LDG- **313306-22**

APPENDIX 1: Response to KCC Report
(Refer to parks report in Appendix B of KCC's planning report for full details)
Issue 3

The Big Space Ltd

drawn PROPOSED SITE BOUNDARY SECTIONS

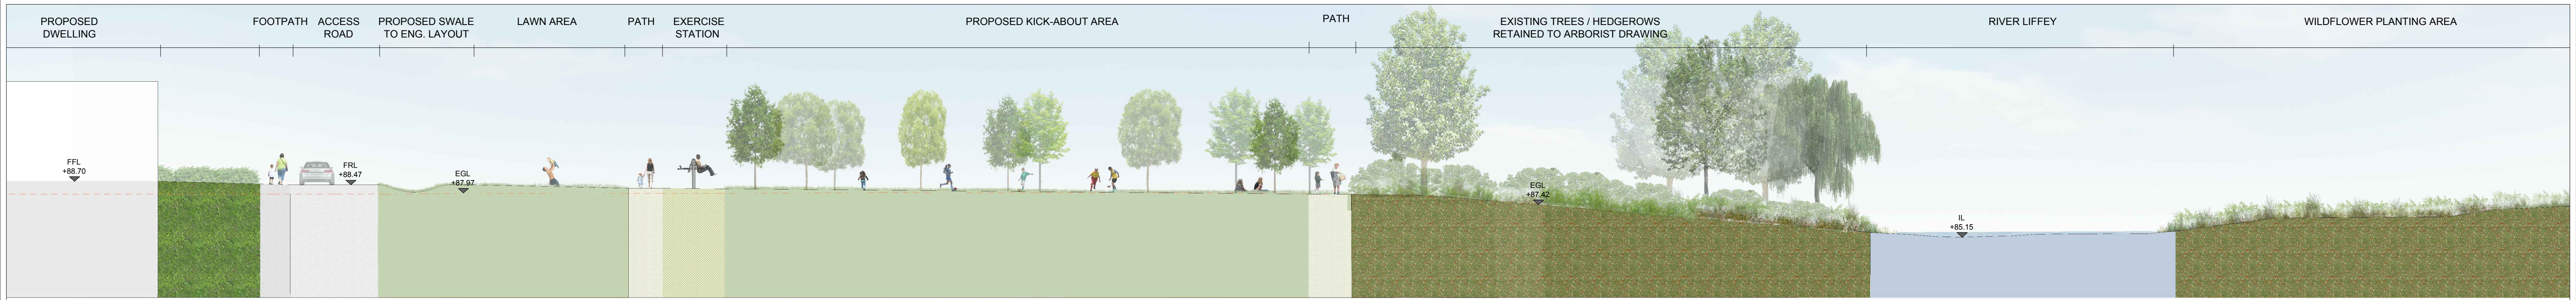
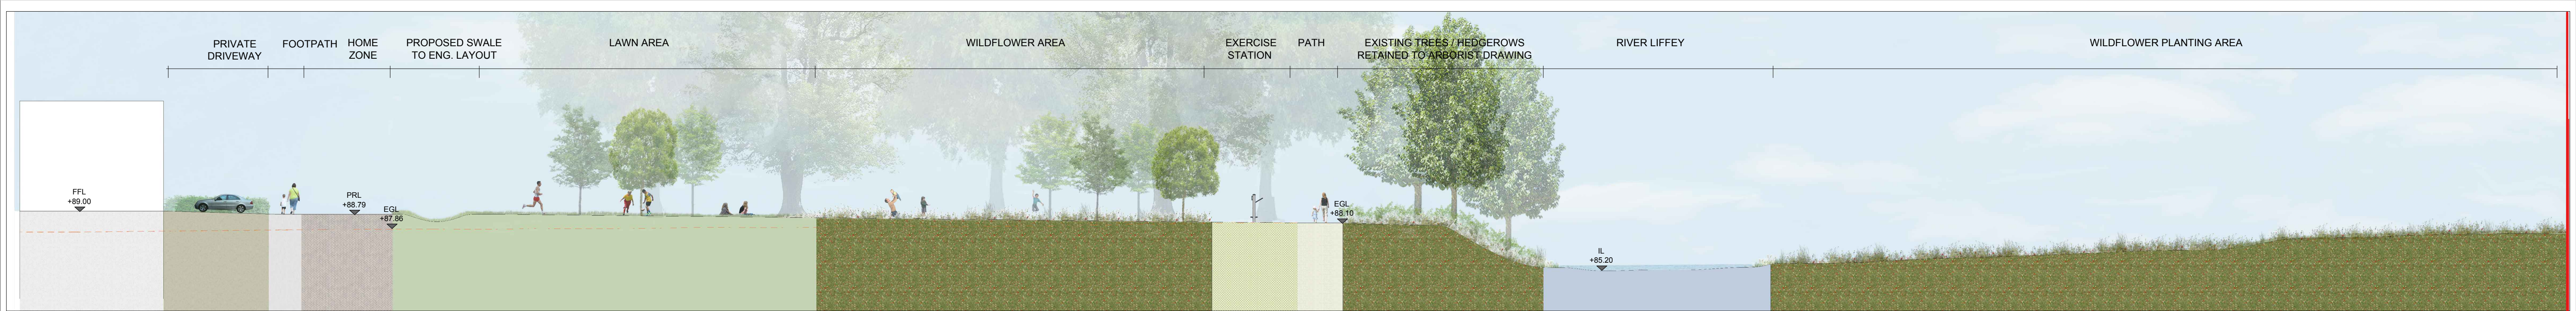
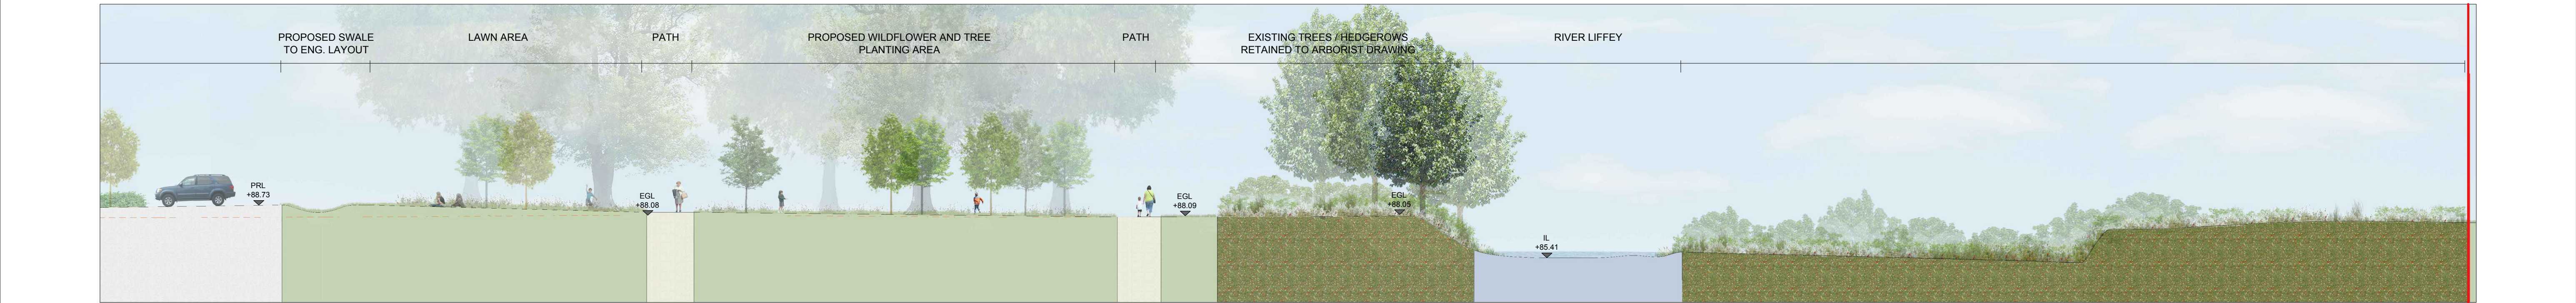
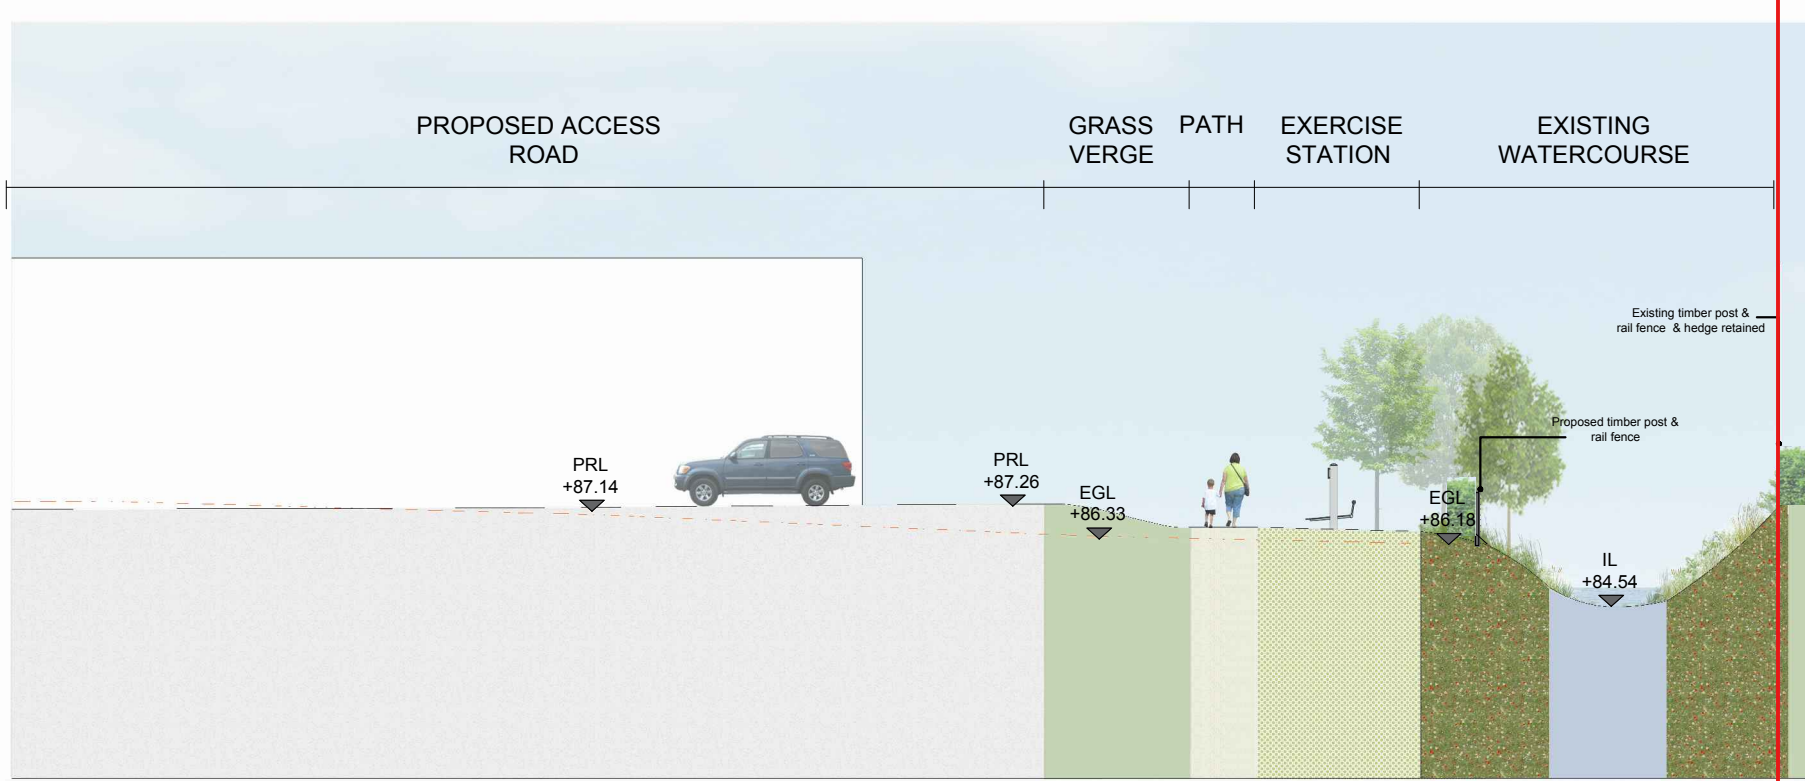
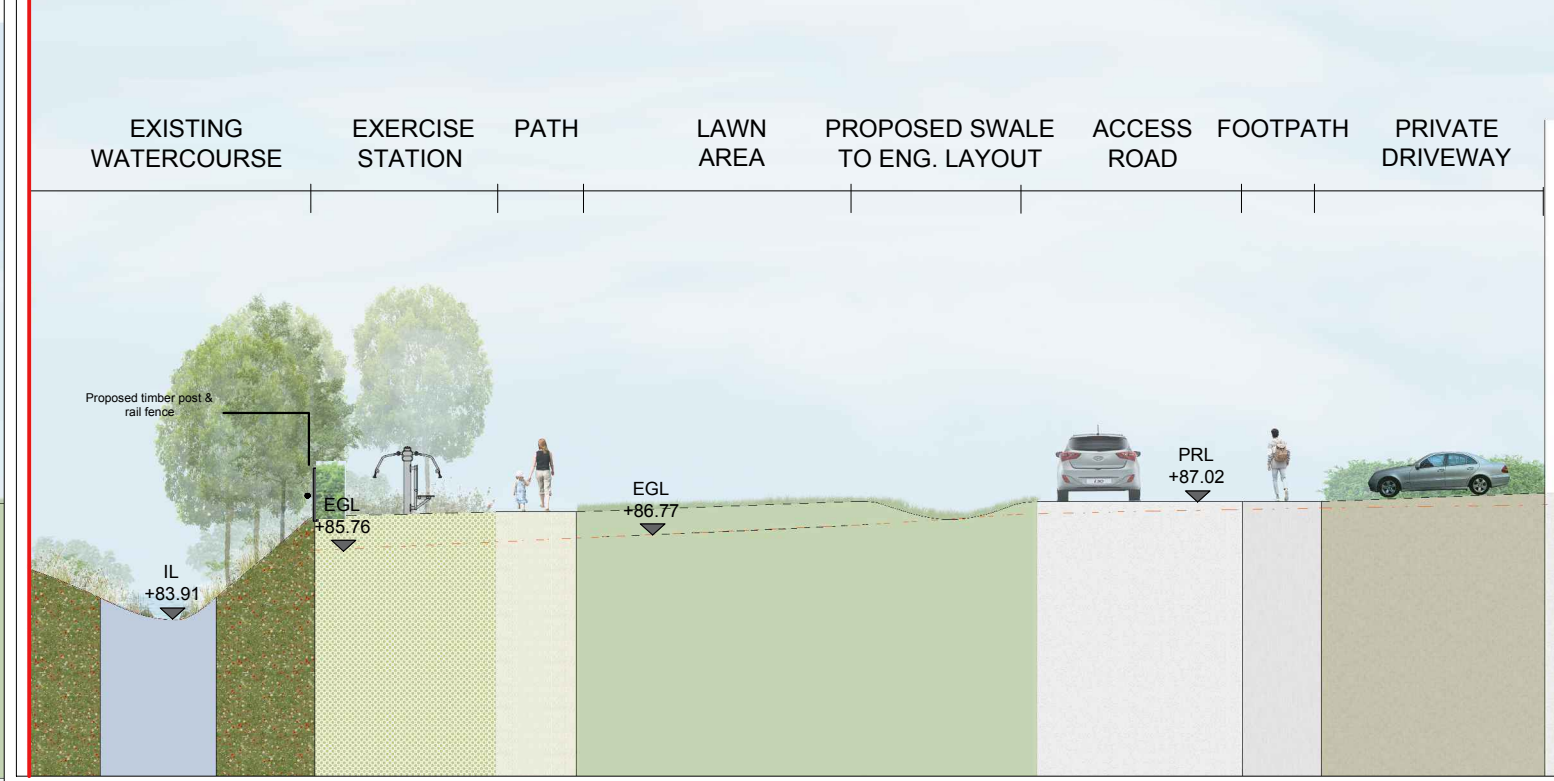
Applicant is requested to show sections drawings (north-south and east-west) through the proposed development to illustrate the existing and proposed finished topography	Refer to architects sections that identifies existing and proposed topography Refer to Sections G-G to L-L on TBS dwg 307
Landscape proposals to detail precisely which locations utilise such systems as 'root barriers'	Refer to TBS dwg 308 for proposed locations of same
Landscape proposals to detail the surface types and edges of all proposed footpaths and cycle tracks.	Refer to engineers dwgs for details of same
Materials and finishes of all proposed seating to be submitted.	Refer to Landscape Development Report, Section 2.2 for detail of Omos bench or similar approved
Landscape design shall ensure that the trees are planted at sufficient distance from any public lighting to avoid future conflict.	Refer to TBS dwg 300 for confirmation of same

<p>The boundary treatment and landscape proposals shall also show a comprehensive suite of section drawings through all boundaries to illustrate existing and proposed finished topography of adjacent areas</p>	<p>Refer to TBS dwgs 306 -307 for proposed boundary treatments inc:</p> <p>Section G-G, H-H, I-I, J-J',K-K' & L-L' in dwg 307</p>
<p>It is a requirement of the Parks Section that the layout plan for the proposed development ensures that the existing trees and hedgerow along the southern boundary are retained and protected during construction.</p>	<p>Refer to arborists dwgs and report for information on same. The revised site plan allows for the retention and protection of the existing hedgerow along the southern boundary. Also indicated on TBS dwg 300.</p>
<p>Comprehensive details including a programme of works shall also be provided for remedial and improvement works to the existing boundary trees and hedgerows.</p>	<p>Refer to arborists dwgs and report for information on same</p>

<p>The boundary details drawing shall also clarify the boundary treatment proposals along the following boundaries of the proposed development:</p> <ul style="list-style-type: none"> • North-western and western boundaries adjacent the Zoned F: 'Open Space and Amenity' lands. • North-western boundary adjacent Wellesley Manor where the existing laurel hedge, post & rail fence and watercourse are located. 	<p>Refer to TBS dwg 306-307 for proposed boundary treatments</p>
<p>It is a requirement of the Parks Section that an appropriate permanent boundary type shall be incorporated in addition to existing and proposed planting (proposed boundary treatment adjacent Great Connell Road). Further to this, the Roads Section report also</p>	<p>Refer to TBS dwgs 306-307 for proposed boundary treatments inc:</p> <p>Section L-L' in dwg 307</p>

TREE PLANTING PLAN & DETAILS

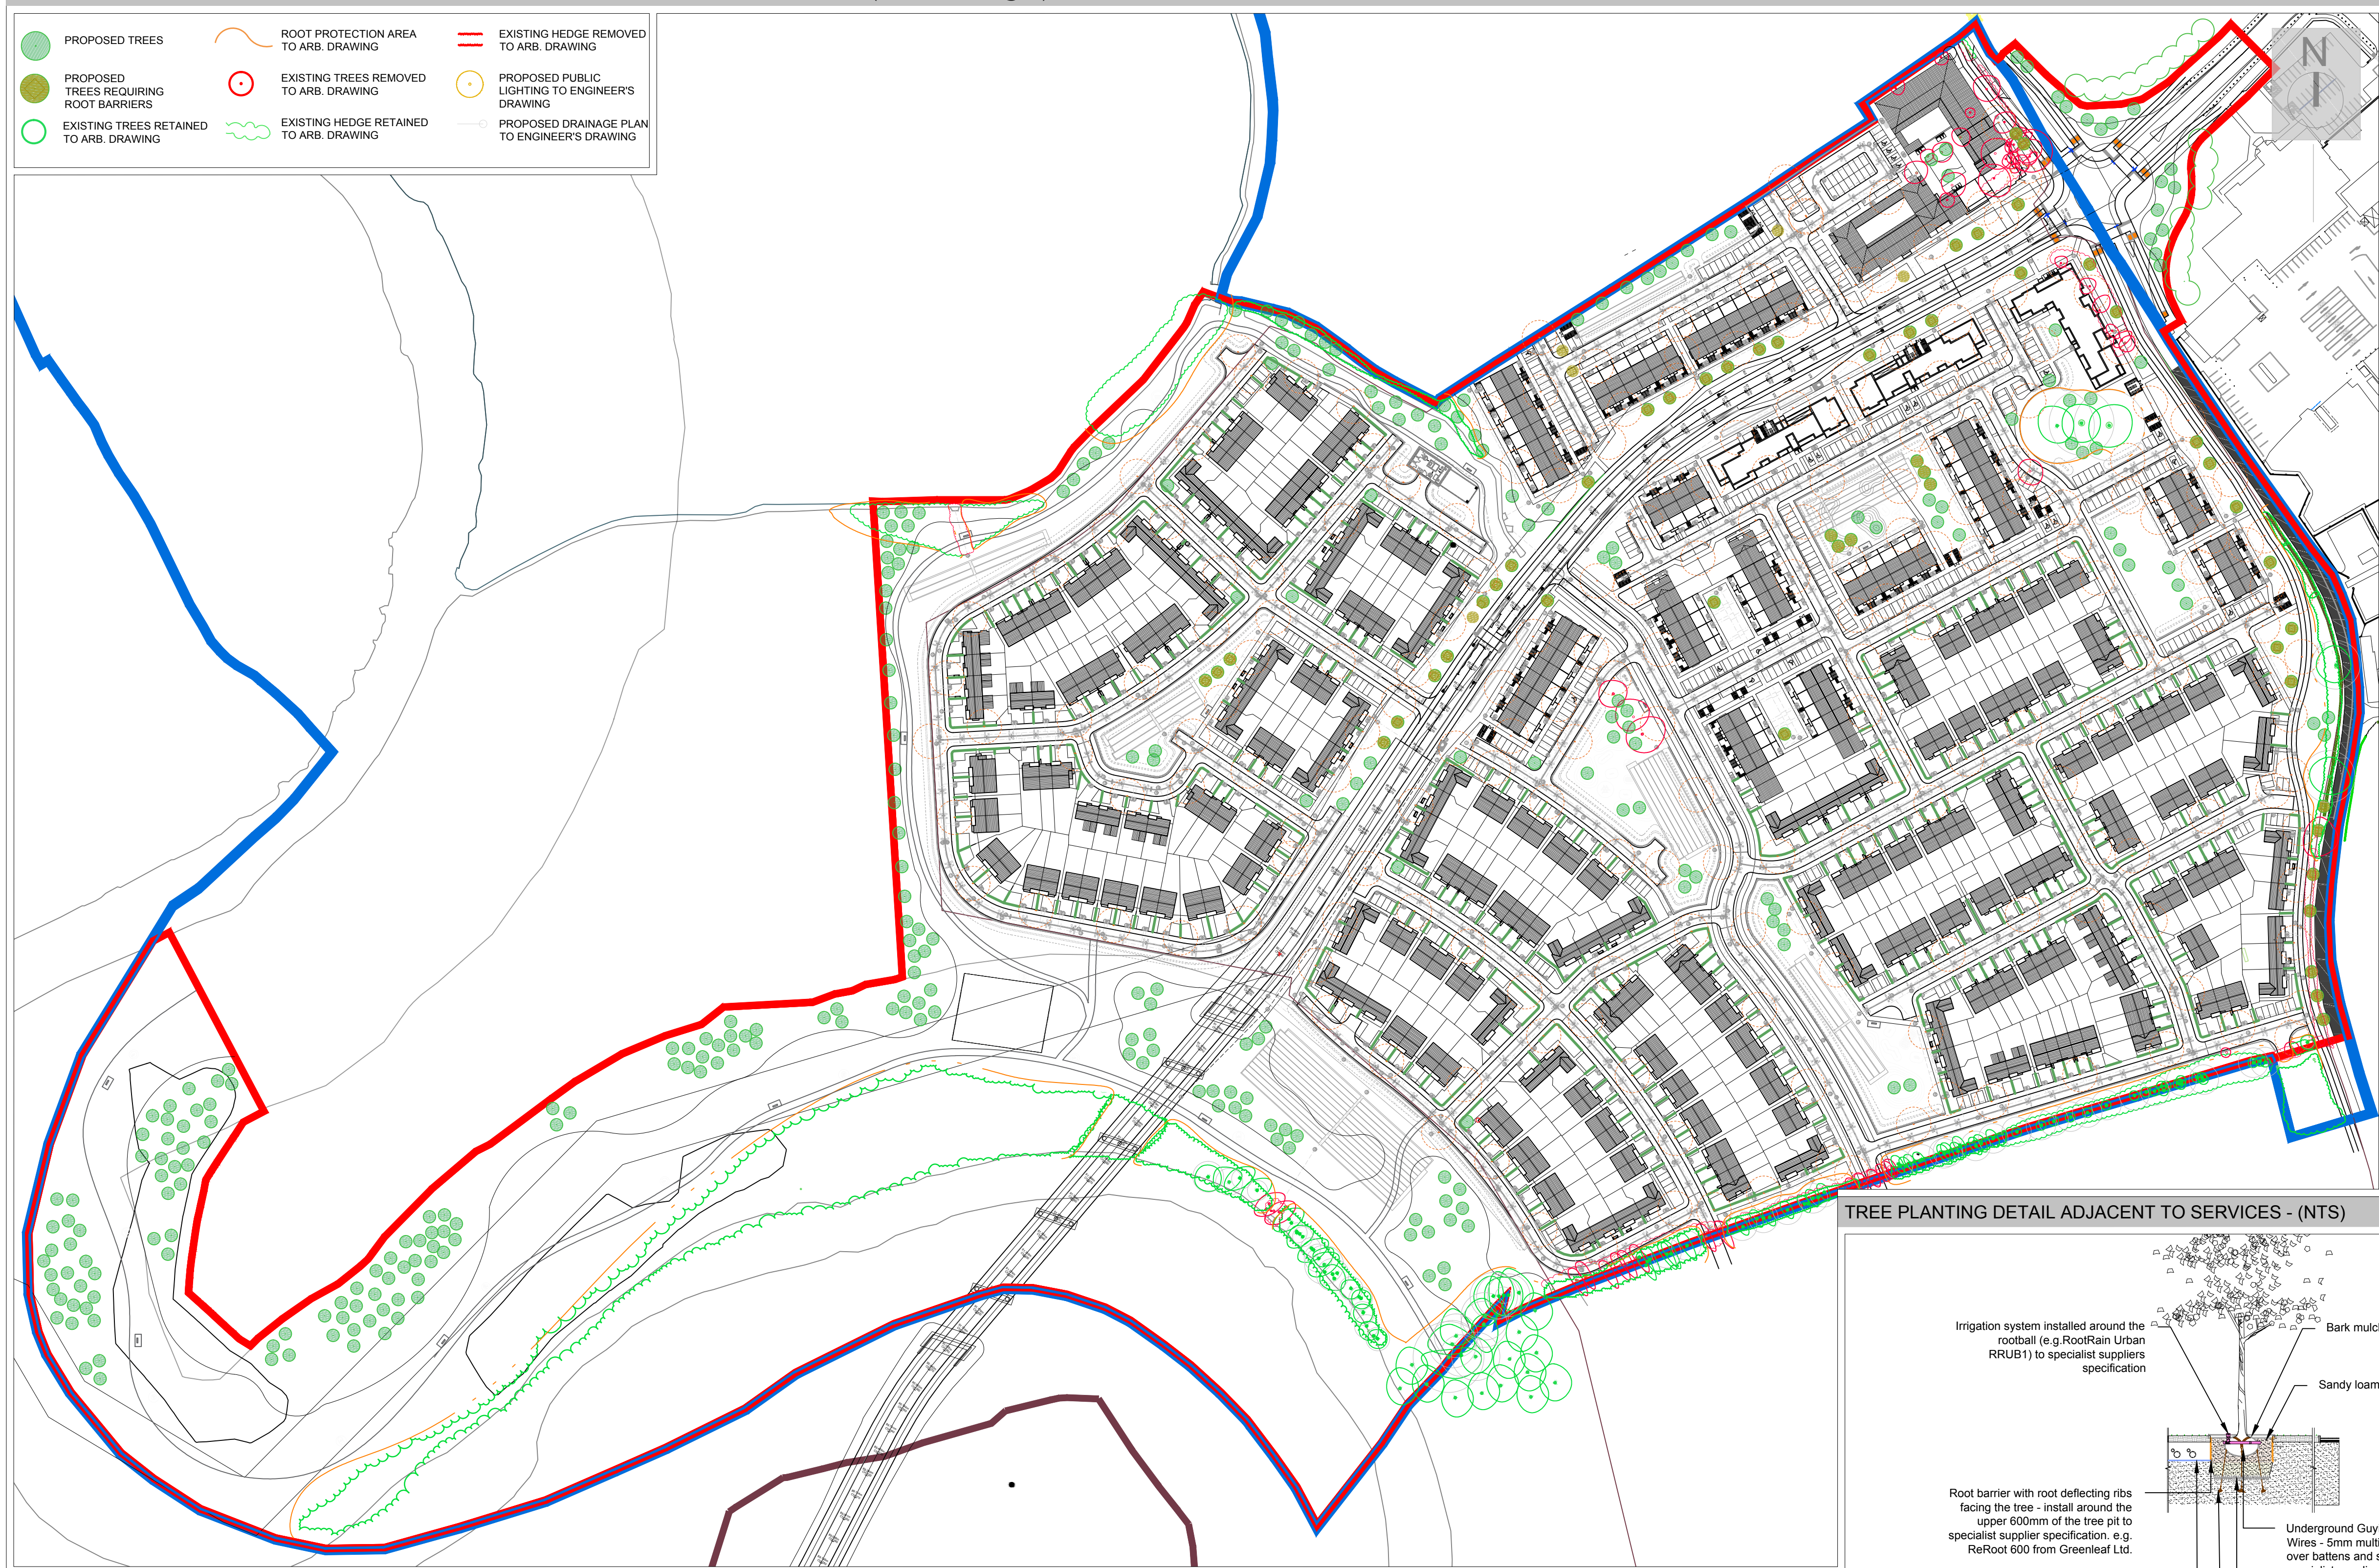
Coniferous tree species to be included in the tree planting mix.	Noted and included in planting schedule on dwg 308 & Landscape Development Report, Section 2.3
Landscape design to detail locations of all proposed underground services and ensure their location will not compromise existing trees and hedgerows, and proposed trees and planting.	Refer to Engineers dwgs and TBS dwg 300-303 which highlights relevant services locations and avoidance of same
Landscape design shall detail locations of proposed underground attenuation located in the open space areas to ensure there is no future conflict between the underground attenuation and any proposed landscaping or features.	Refer to Engineers dwgs and TBS dwg 300-303 which highlights relevant services locations and avoidance of same
Landscape design shall detail any existing or	There is a wayleave along the
